Subject: RE: Planning Consultation on BE/21/20/DOC

Engineers comments in respect to surface water drainage;

APPLICATION NO: BE/21/20/DOC

Site Address: Land At Salt Box West Of Shripney Road Bognor Regis PO22 9NW

HYDROCK PROJECT NO.	SCALE @ A1
C-13319-C	1:250
STATUS DESCRIPTION	STATUS
TENDER	D2
DRAWING NO. (PROJECT CODE-ORIGINATOR-ZONE-LEVEL-TYPE-ROLE-NUMBER)	REVISION
SAL-HYD-PH2-ZZ-DR-C-7012	P03

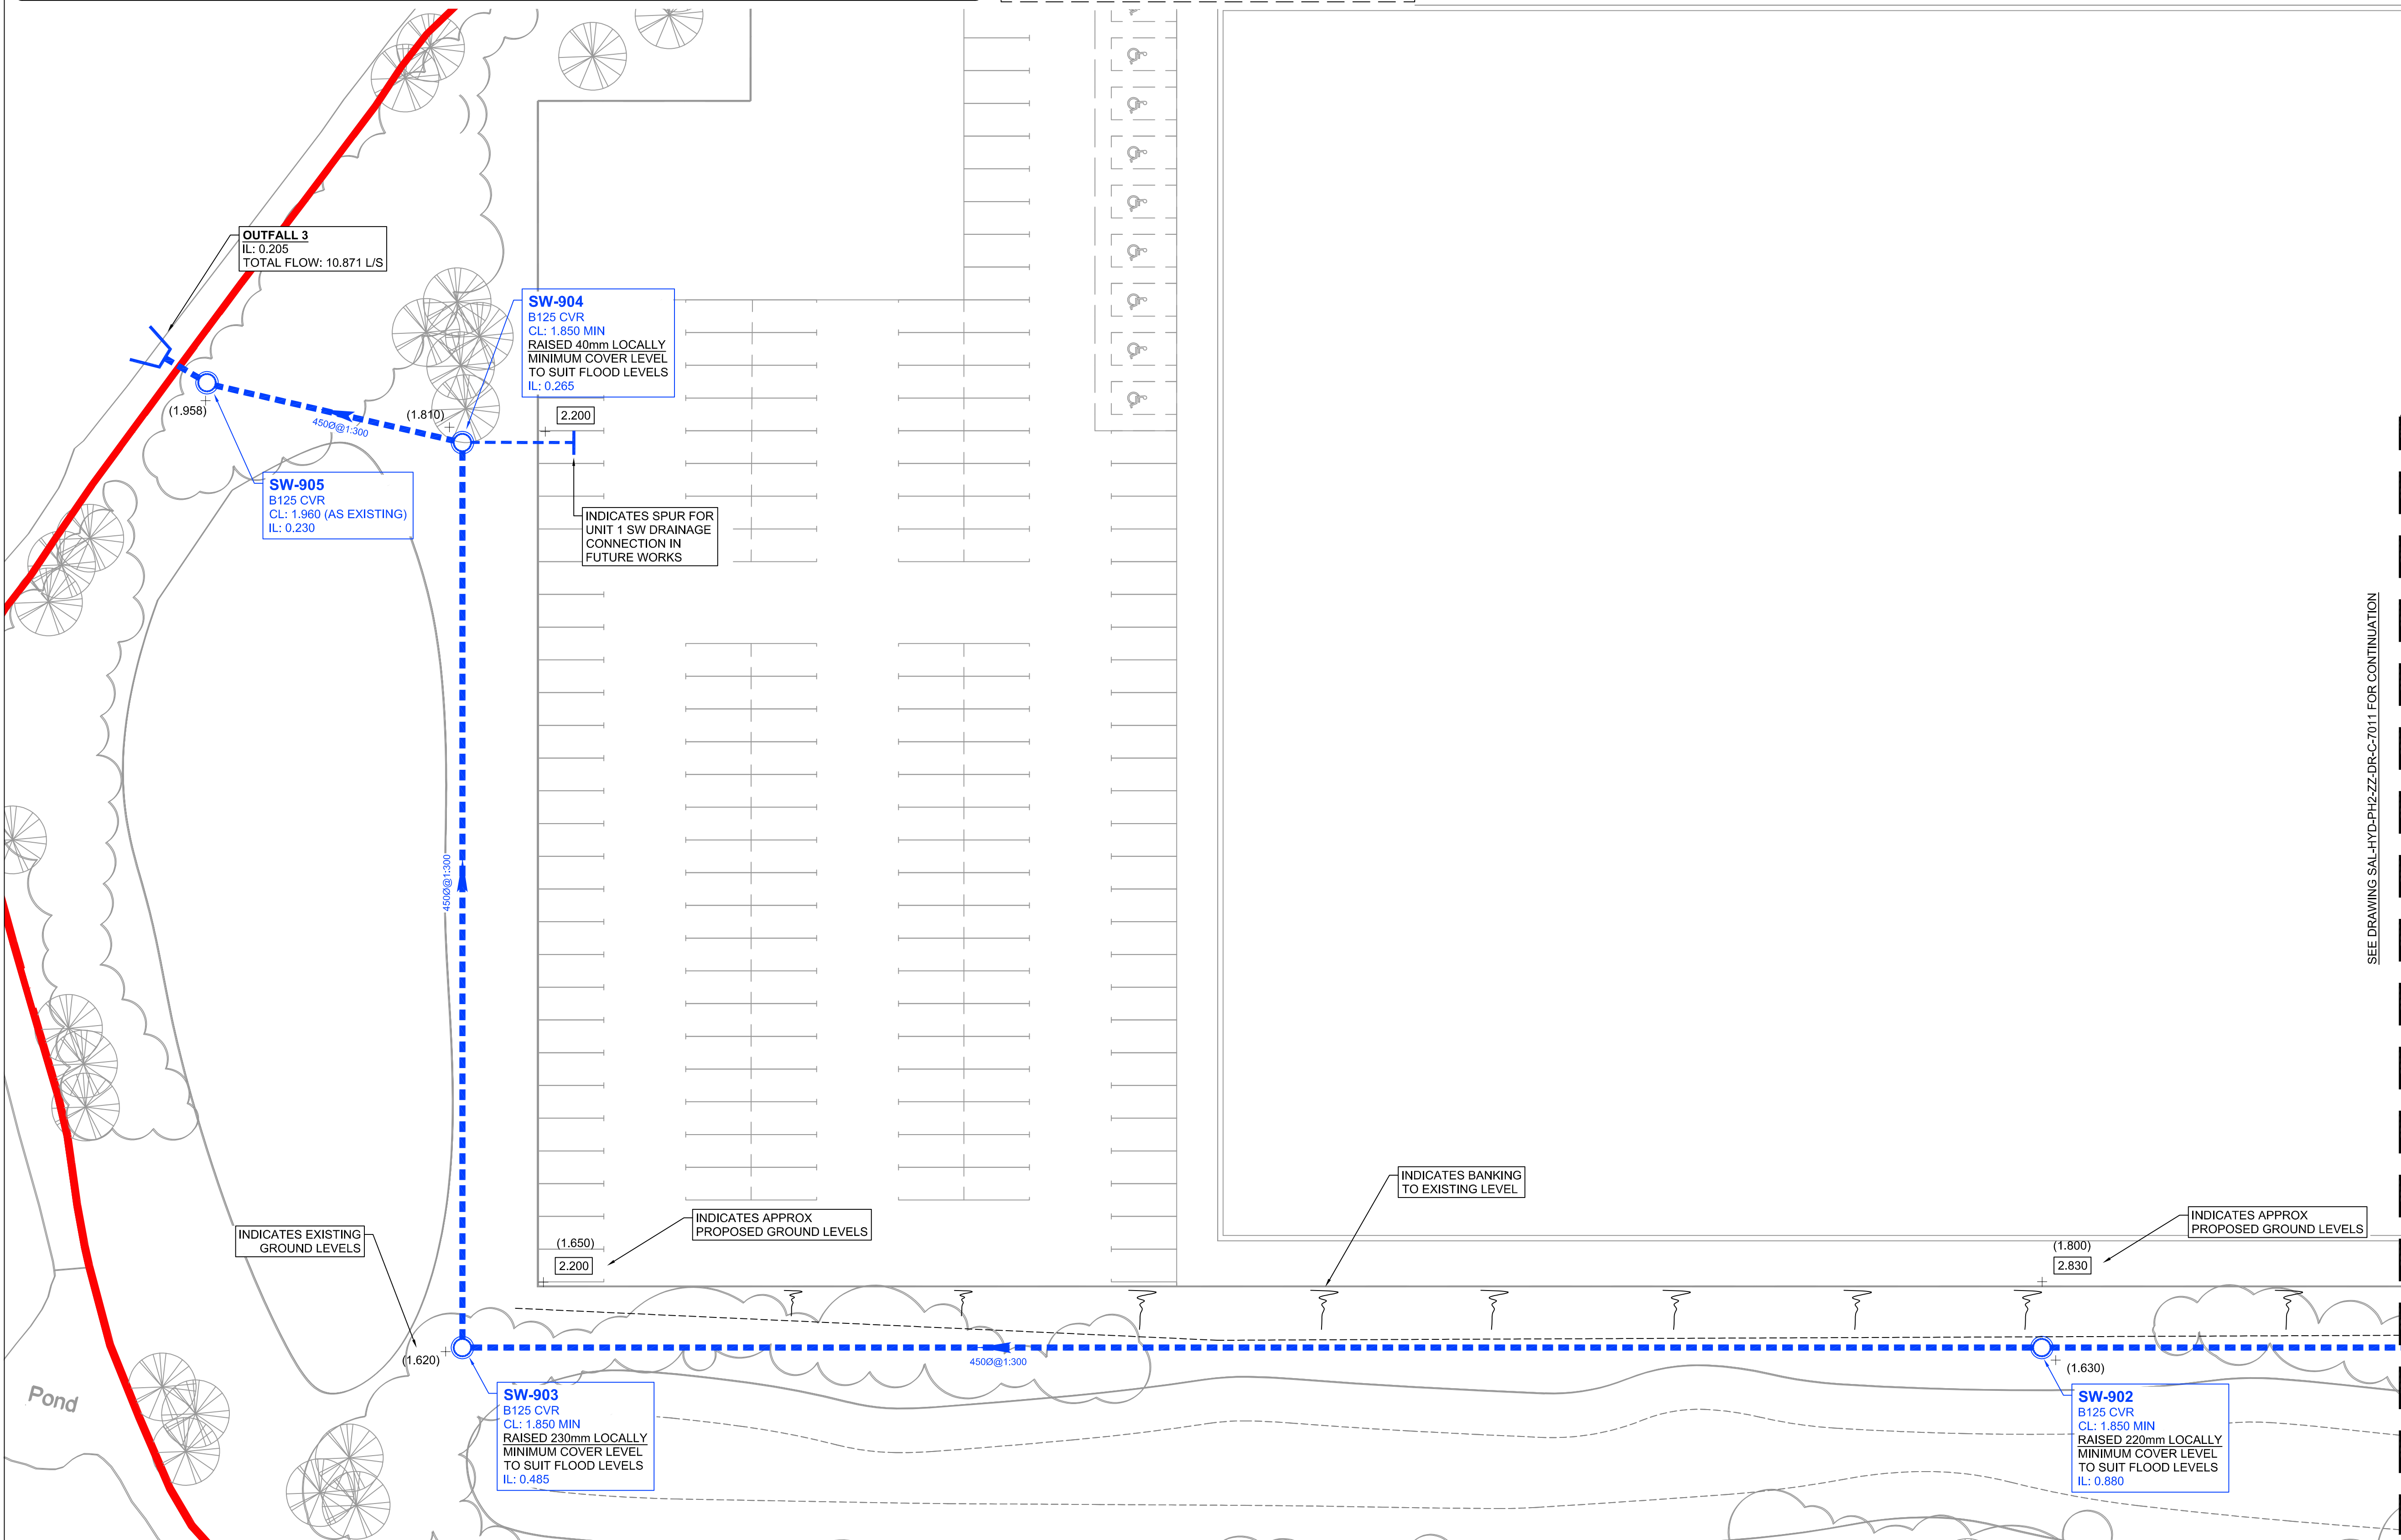
9. Drawings 7011 and 7012 – Remove any trees etc being shown within proximity of the proposed pipeline.
10. Improve gradient FC-401 to 01-401 to min 1 in 400.

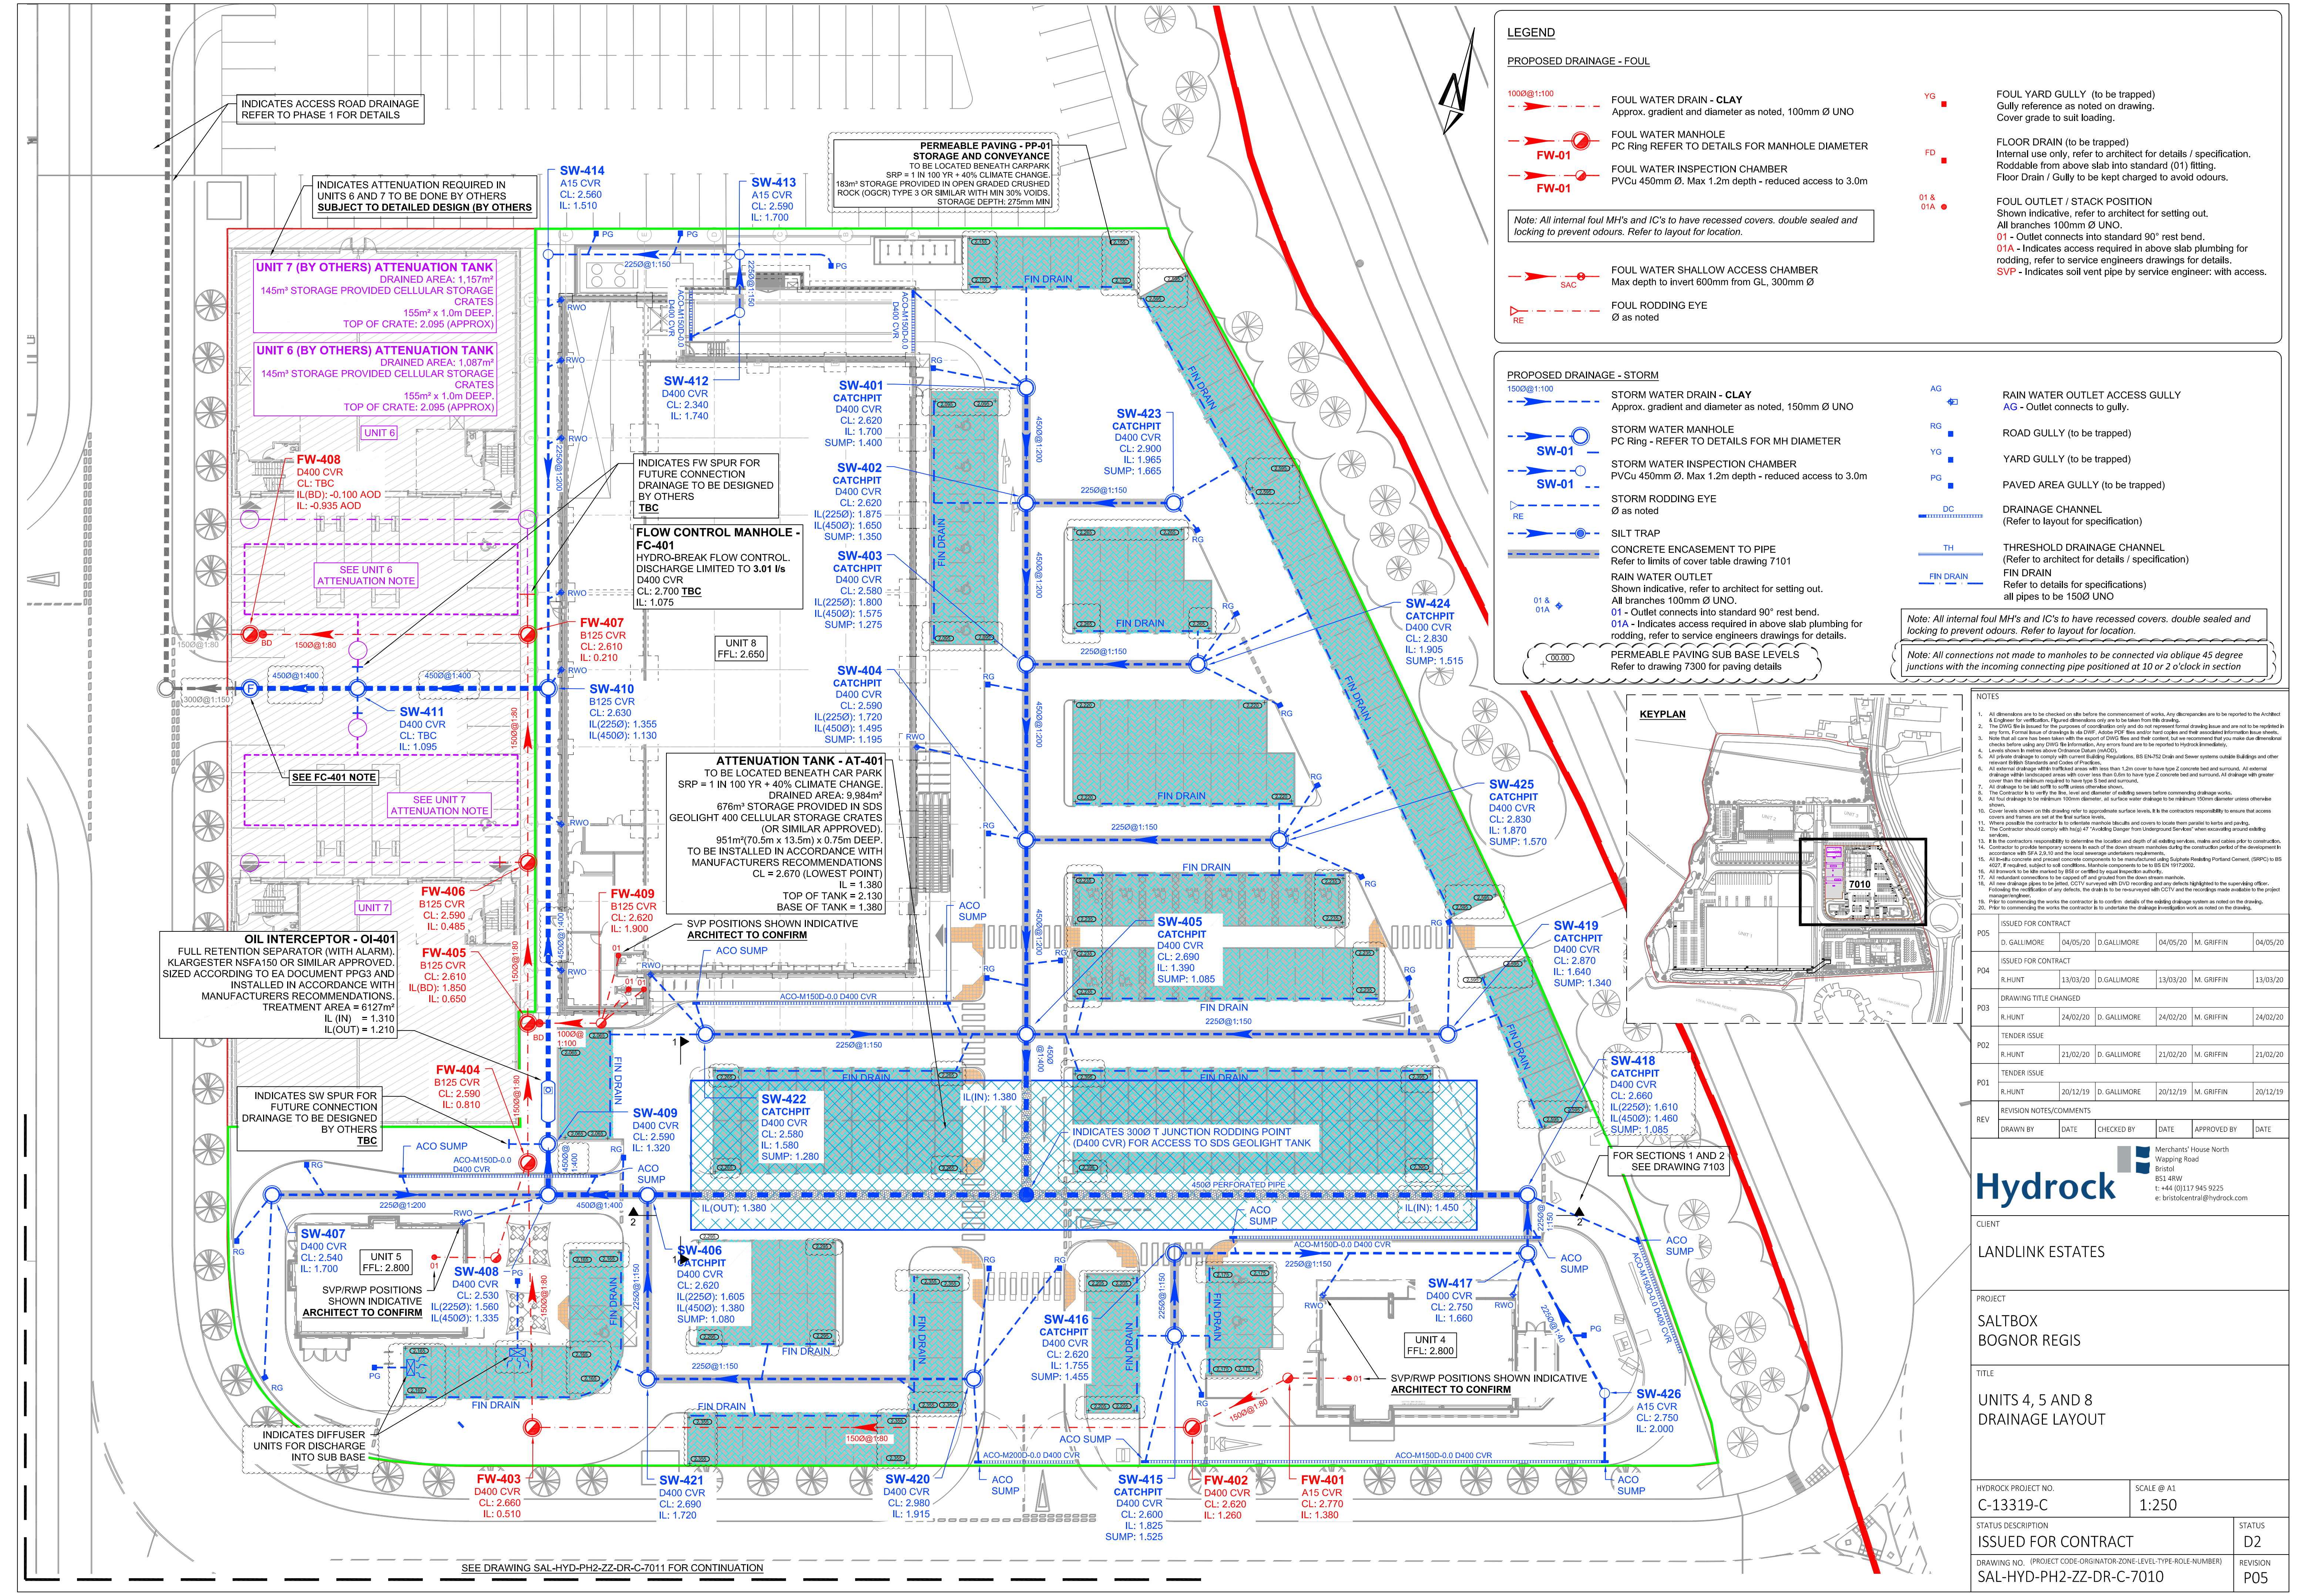
14. Drawing 7010 – specify sub base levels for ALL permeable paving areas. On drawing 7300 – add note to refer to sub base levels on drawing 7010.
15. Drawing 7010 - SW-405 to tank – specify pipe diameter and a reasonable gradient.
